**Bassetlaw**  
**DISTRICT COUNCIL**  
 — North Nottinghamshire —

Our Ref: 20/01594/COND  
 Officer: Mandy Freeman  
 Email: [planning@bassetlaw.gov.uk](mailto:planning@bassetlaw.gov.uk)

**Discharge of Conditions**

**Location** Land Rear Of And Including Robin Hood Inn High Street Elkesley  
**Proposal** Discharge of Conditions 3, 4, 6 and 7 of P.A. 18/01197/FUL - Demolish Garages And Erect 4 Dwellings With Parking And Turning Head

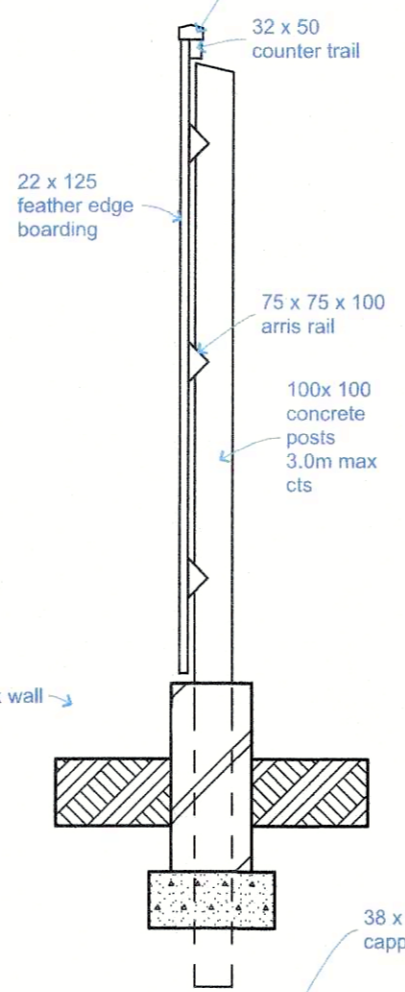
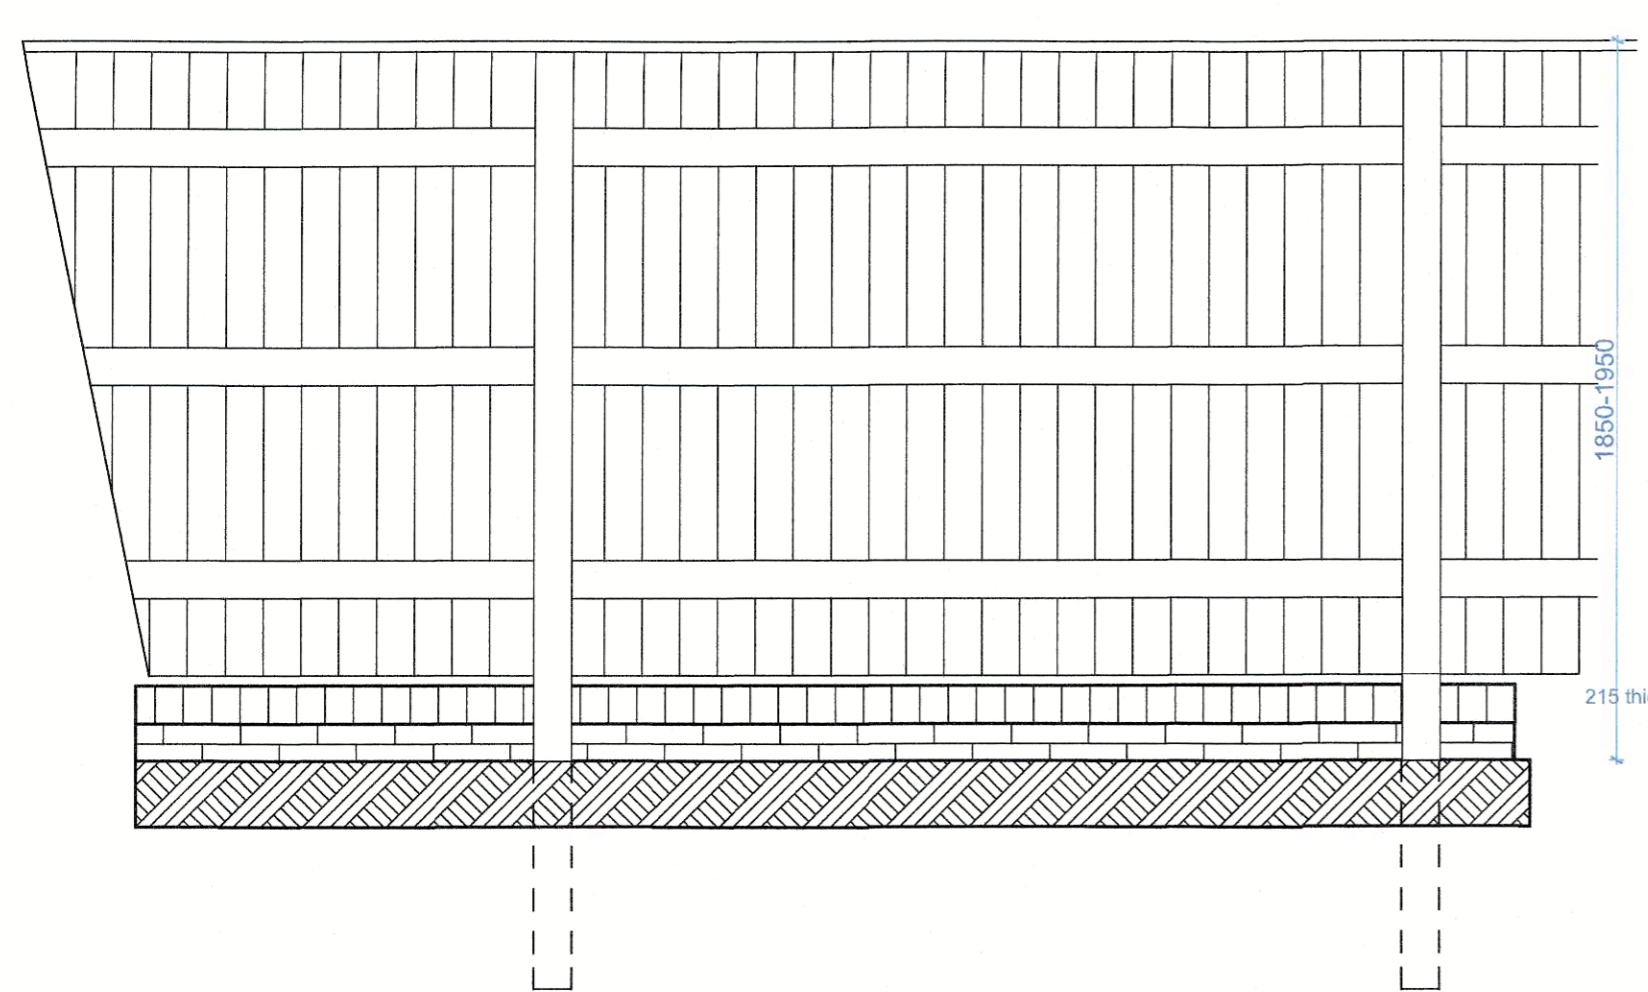
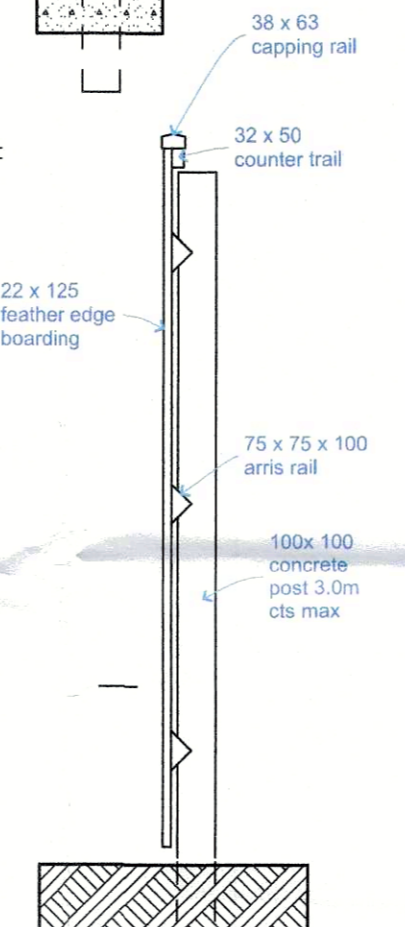
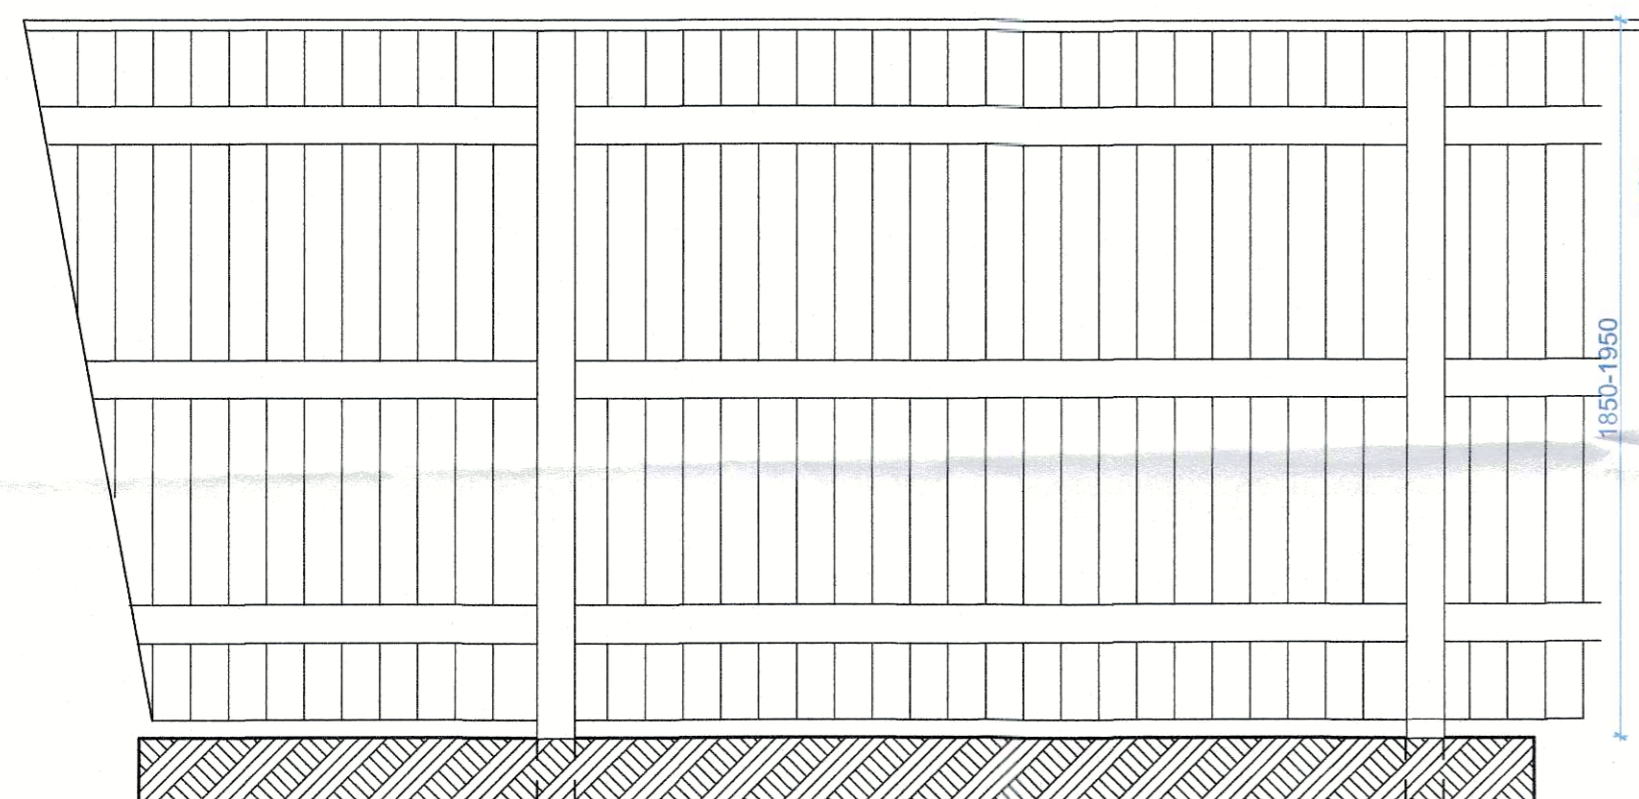
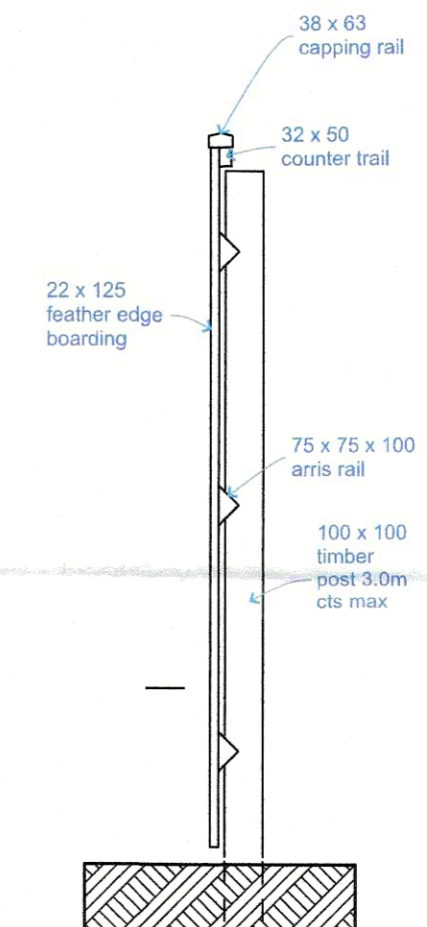
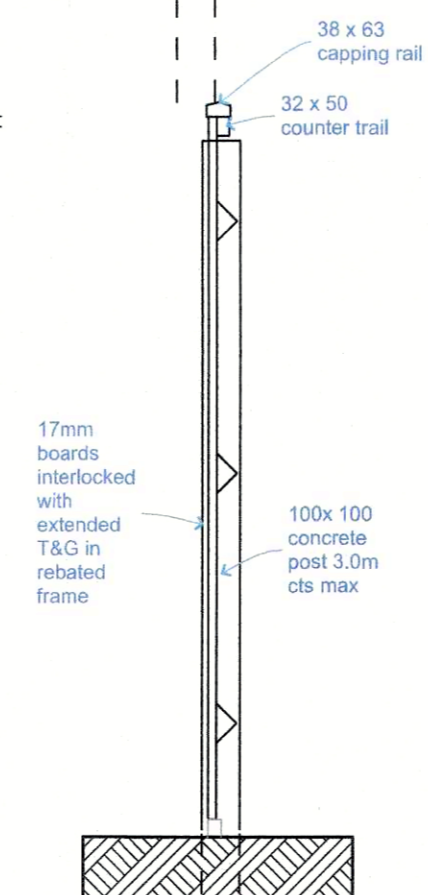
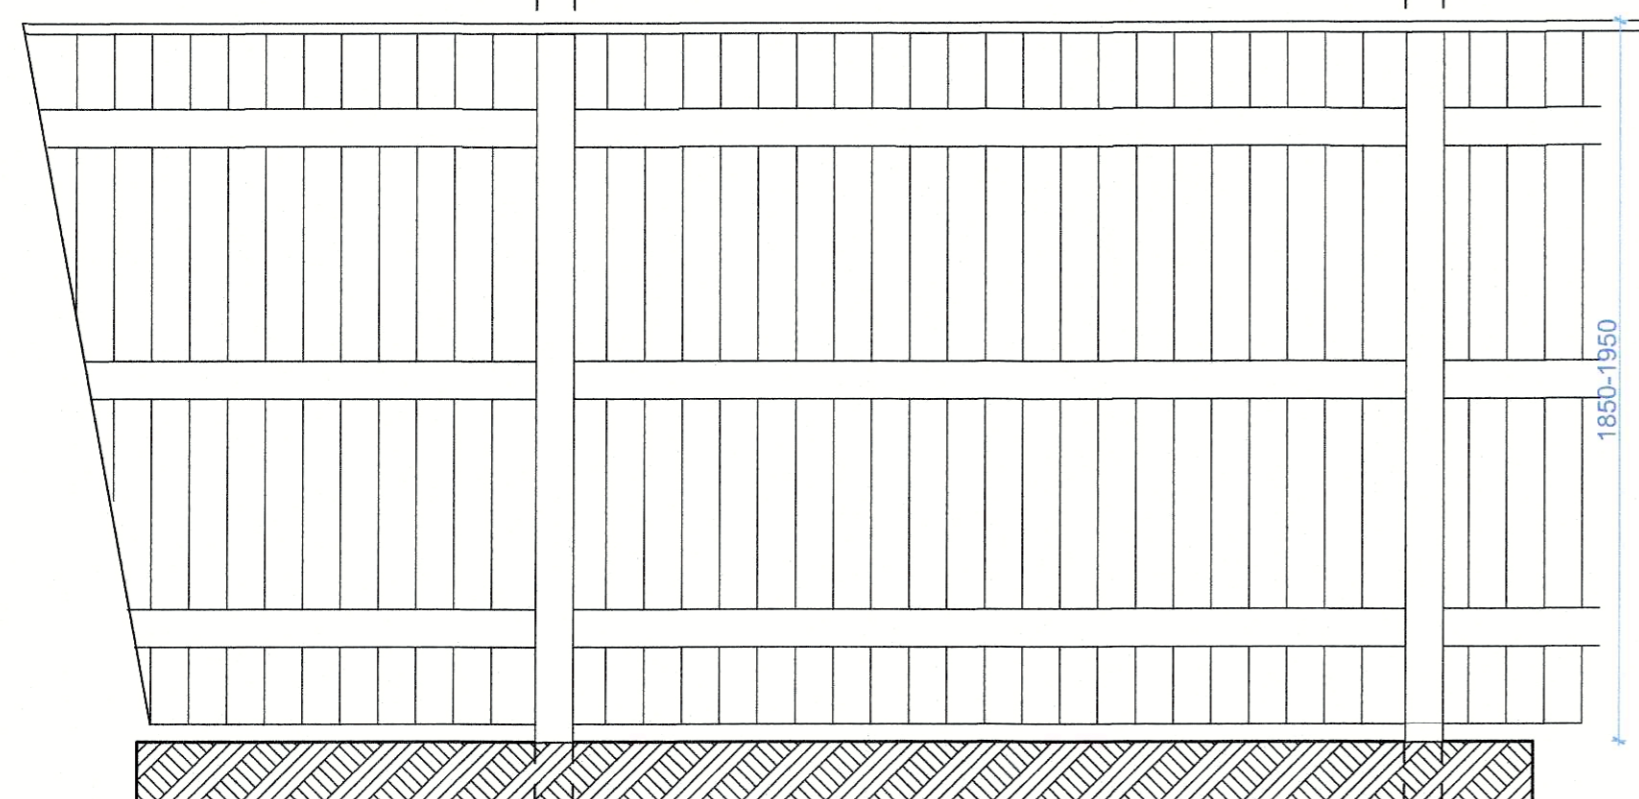
Condition 4 will need further consideration to the boundary treatment on the eastern boundary to provide a brick wall.
